Application No: K/17/22/PL
Site Address: Panorama Golden Acre Kingston BN16 1QP
Description of works: Conversion of existing 2 No flats into 1 No dwelling, single-storey extension with a sloping roof, new porch on ground floor, conservatory at first floor and roof extension, replacement of existing windows, doors and roof tiles. This site is in CIL Zone 4 and is CIL Liable as new dwelling.

Thank you for your internet representation made on 7th July 2022 which has been recorded as an objection with the comments as follows:

PROPOSED SECOND FLOOR PLAN 1:50

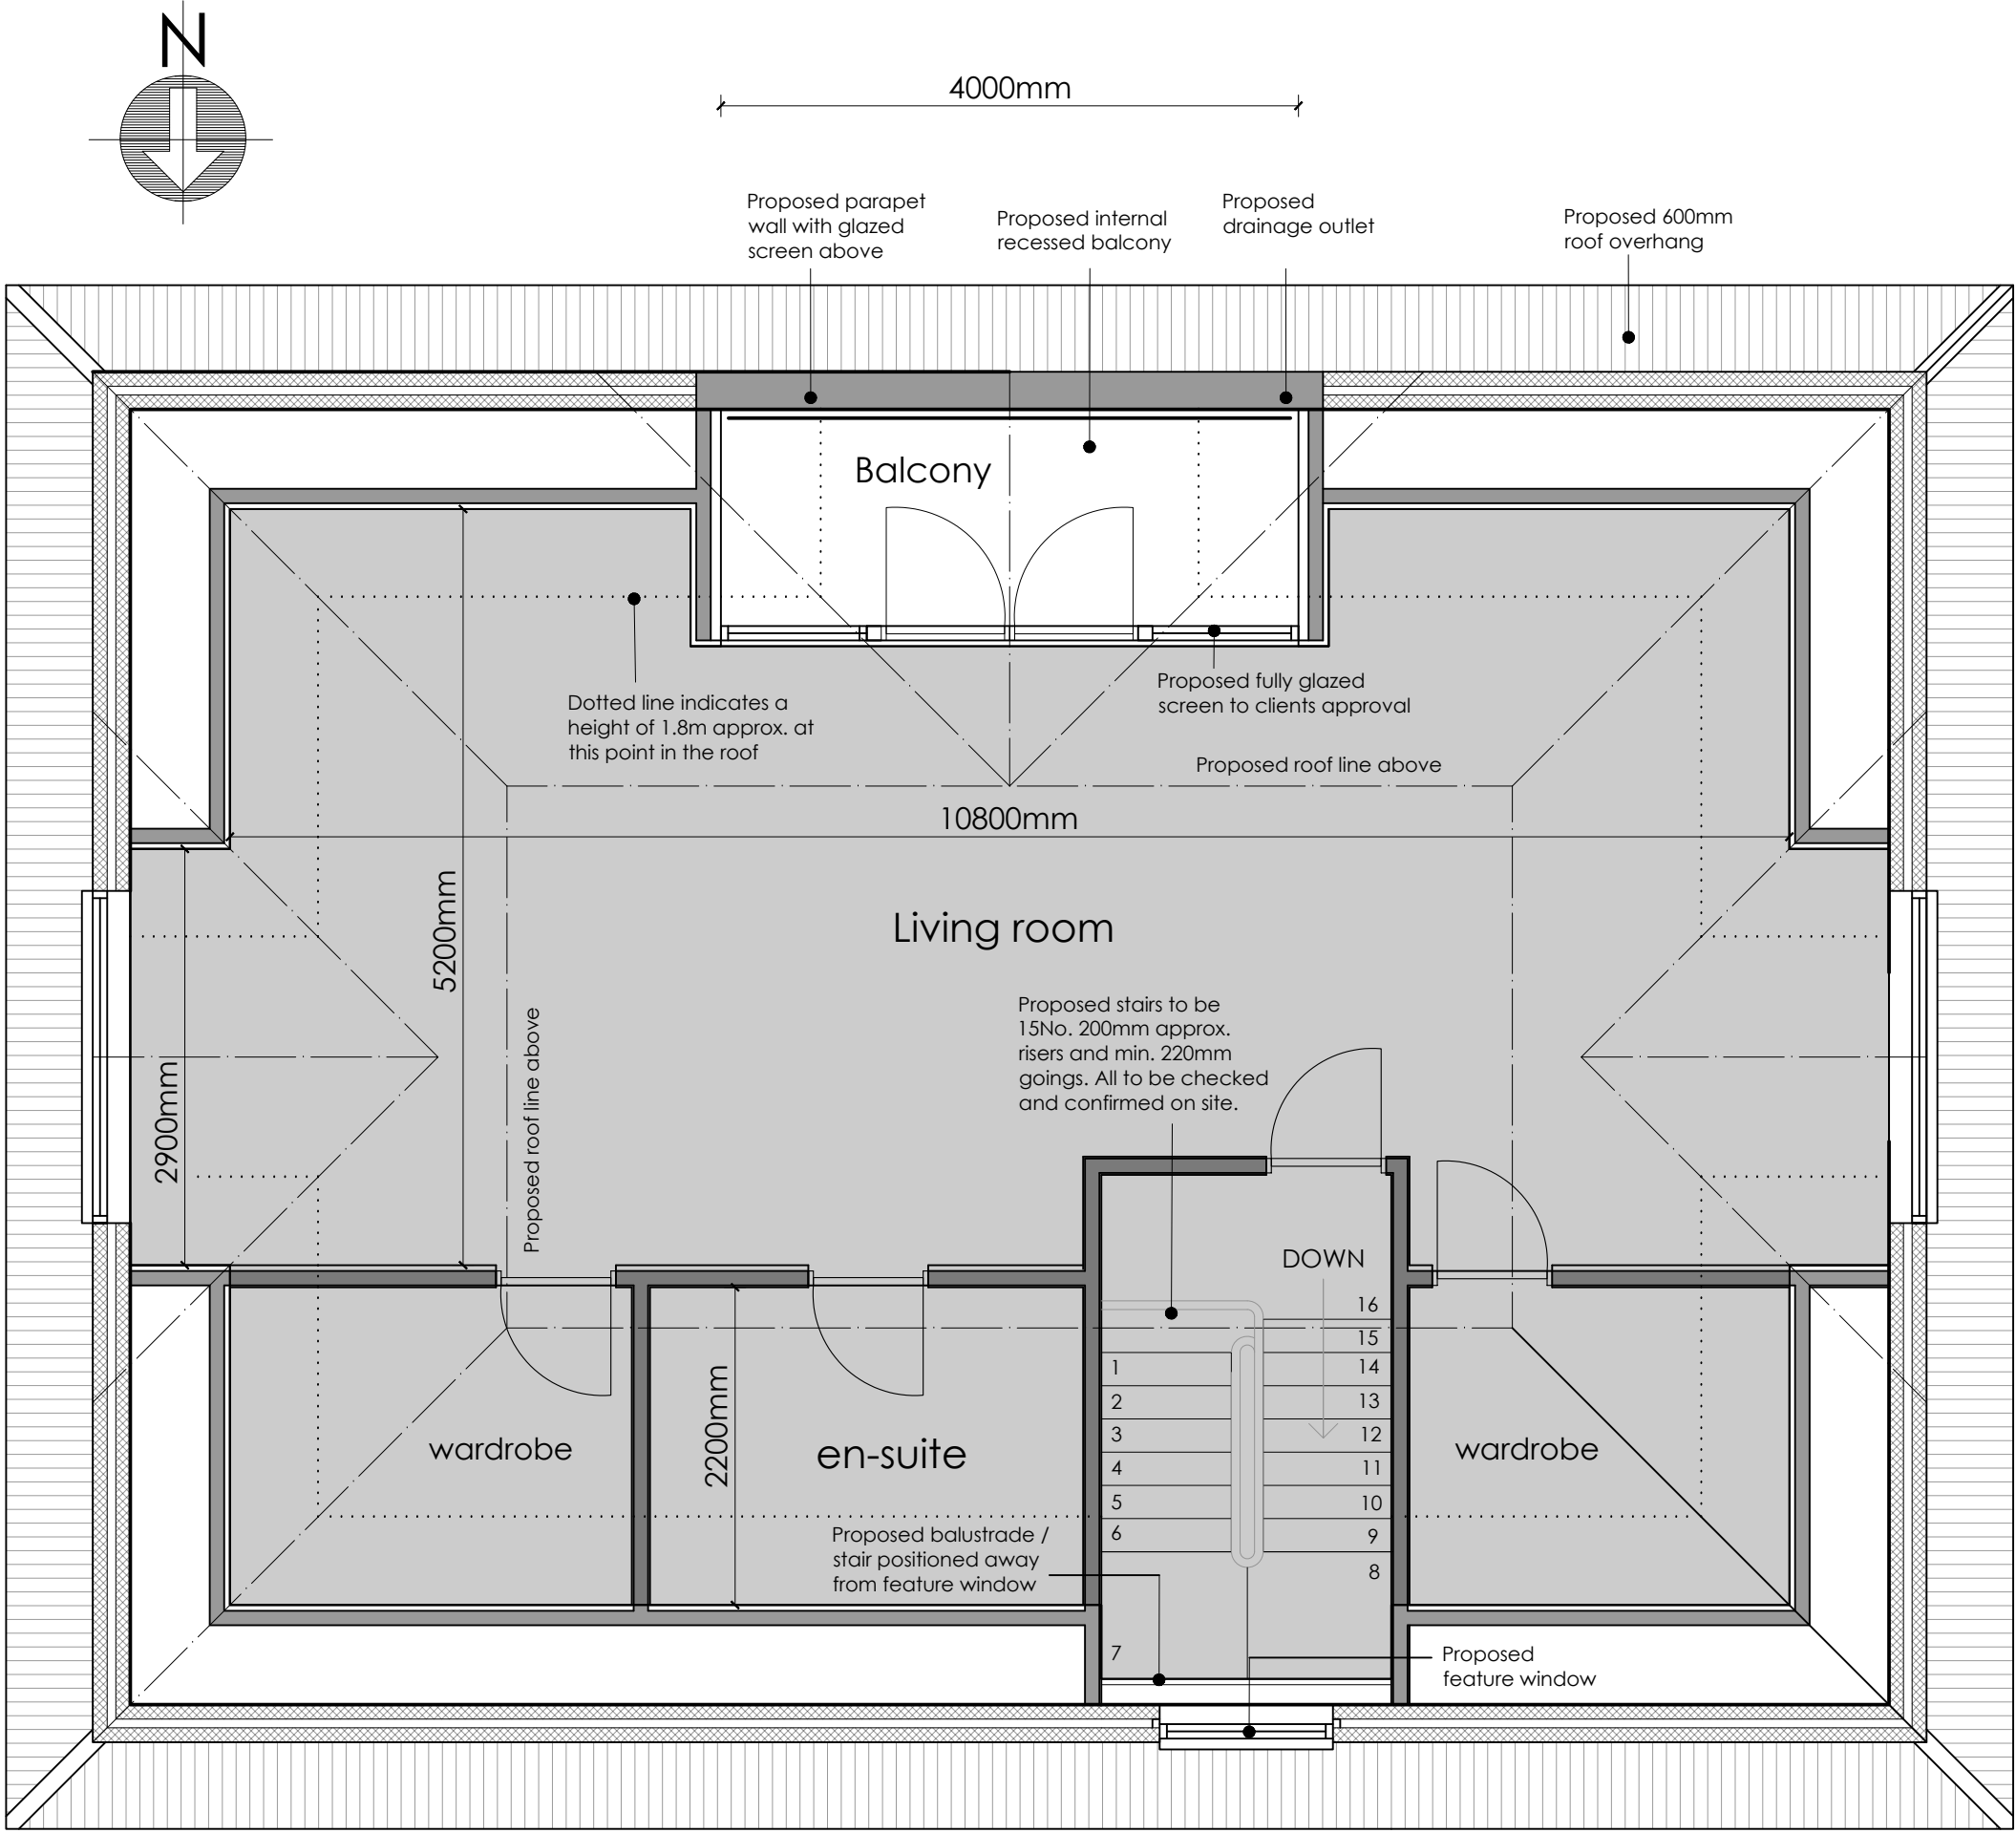
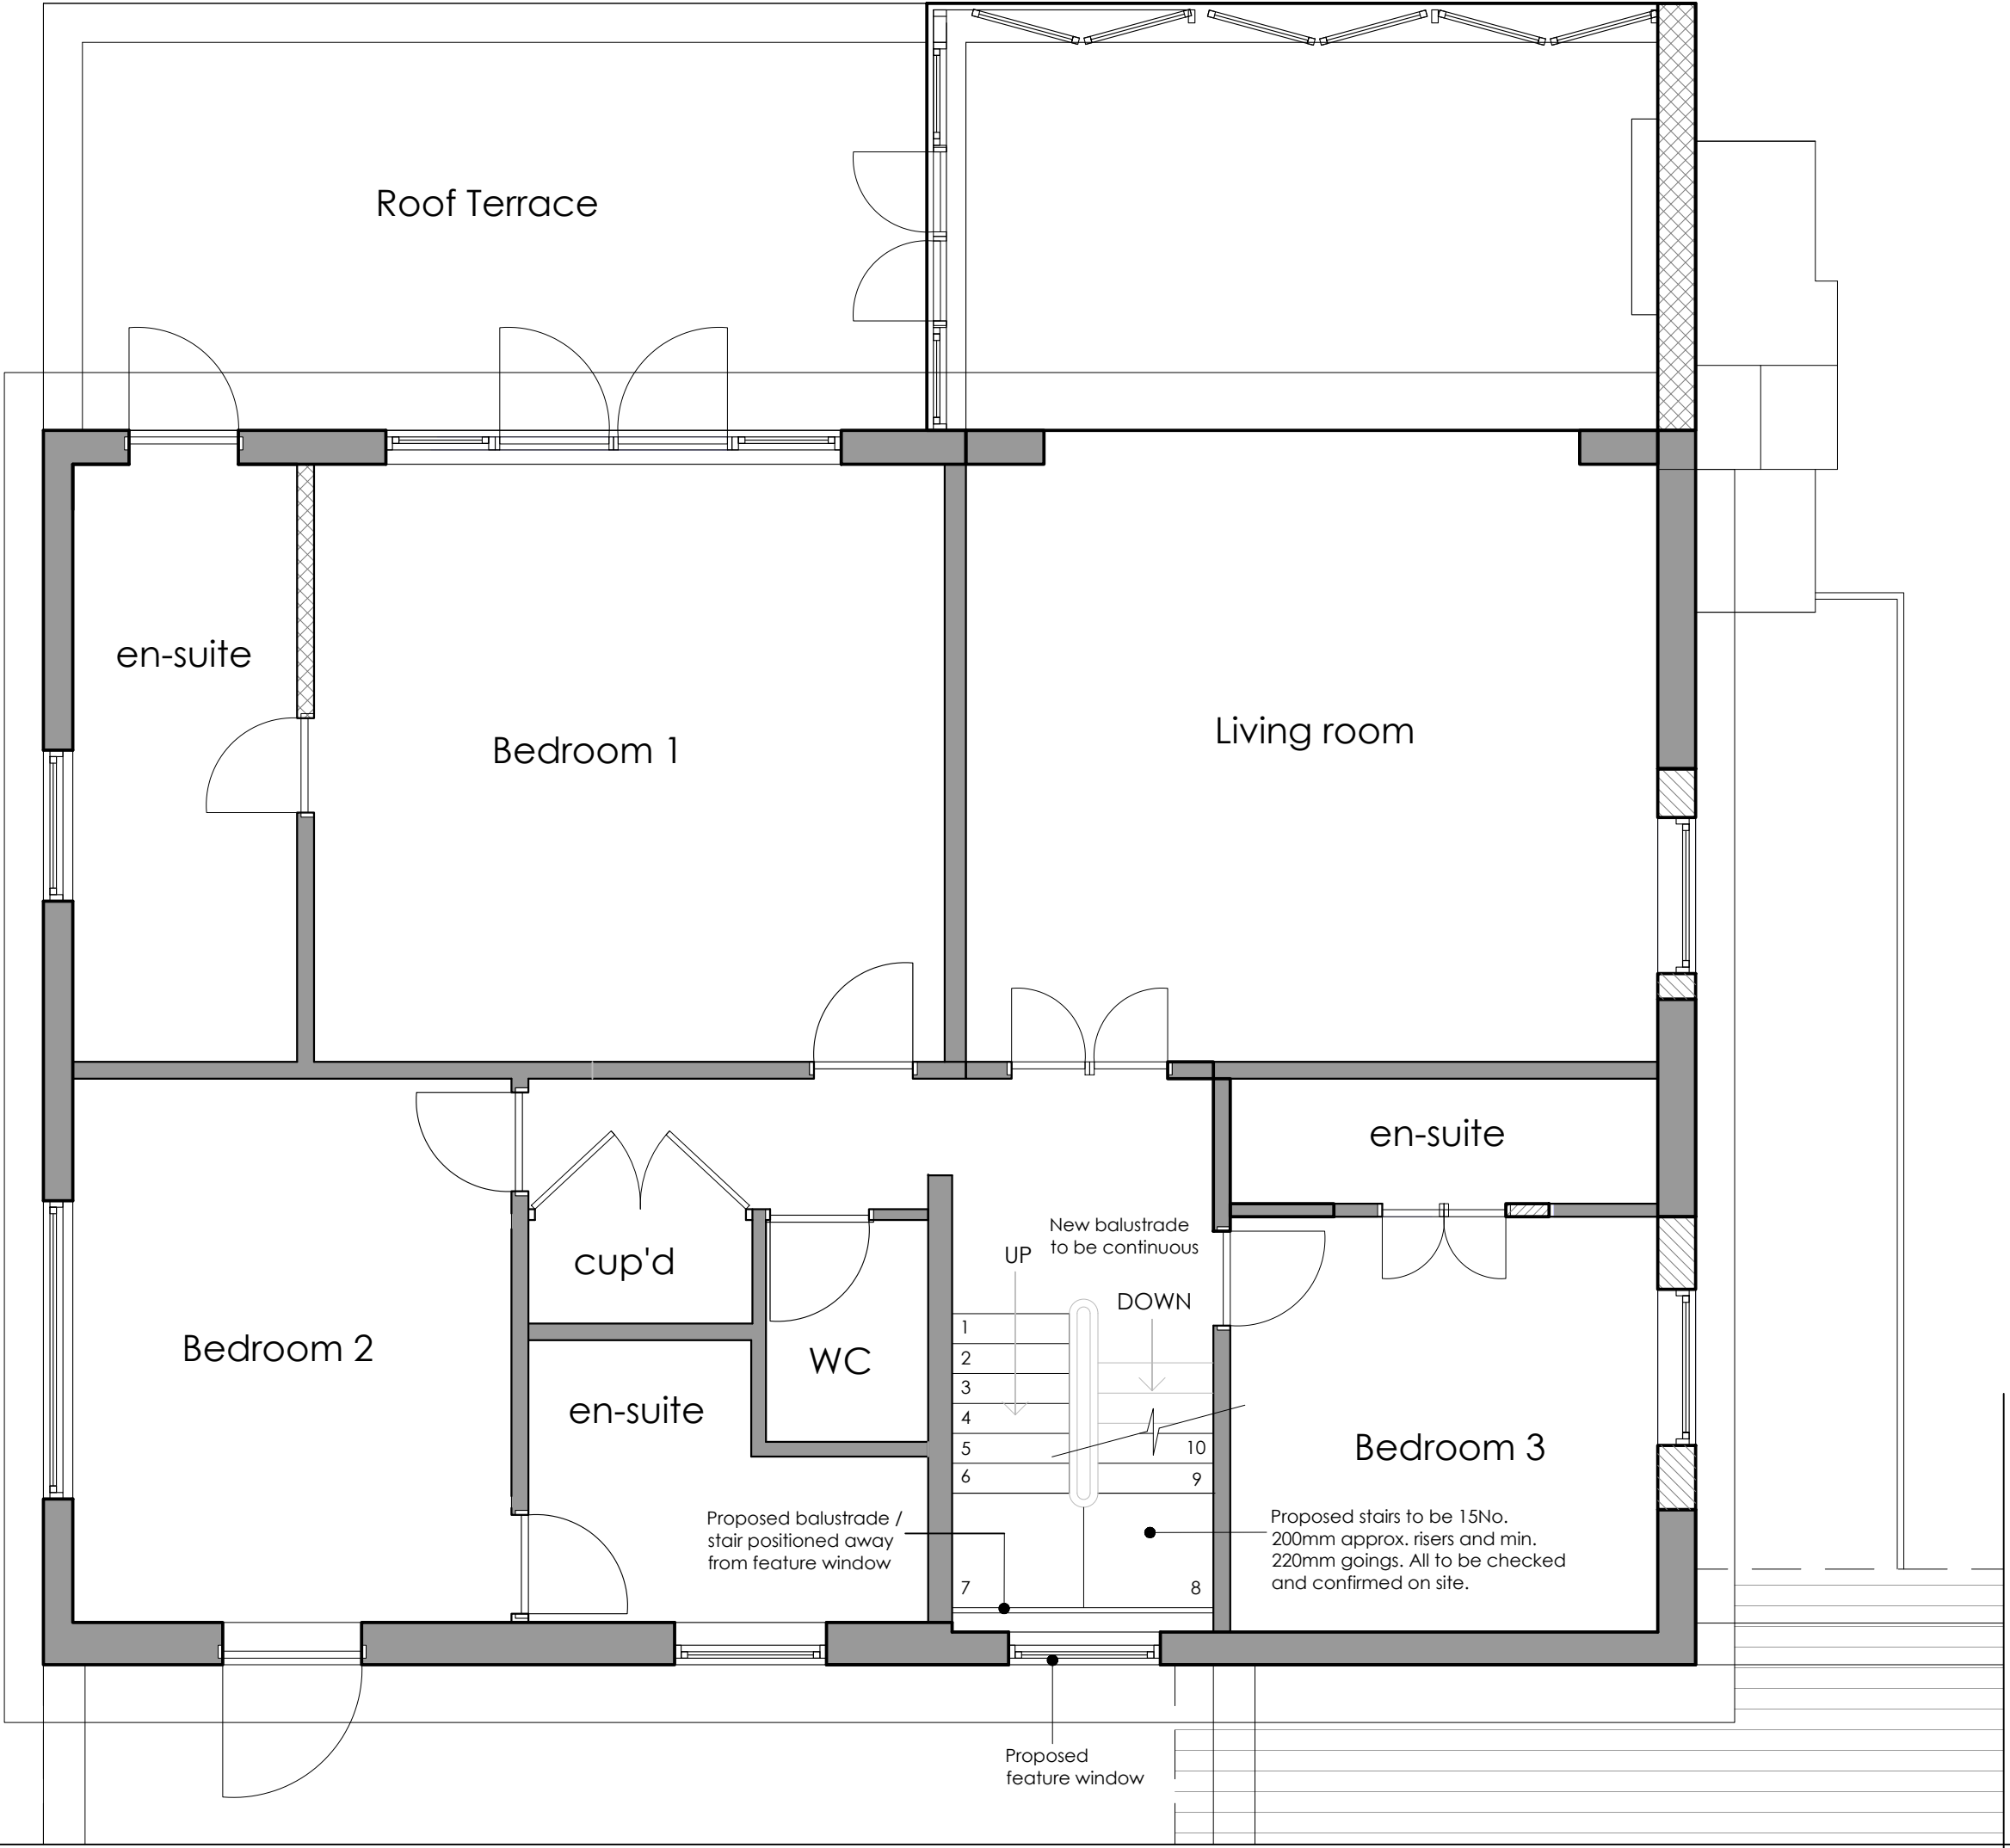
It is also troubling that the drawings only show screening on the southern smaller balcony, but do not show any on the northern terrace conditioned as part of the approval of K/40/20 (Condition 4). Screening on this extensive northern terrace is essential otherwise the amenity and privacy of the neighbouring properties to the north-east would be severely compromised. It might also be appropriate to condition obscured glass for the large second floor windows if they overlook neighbouring properties.
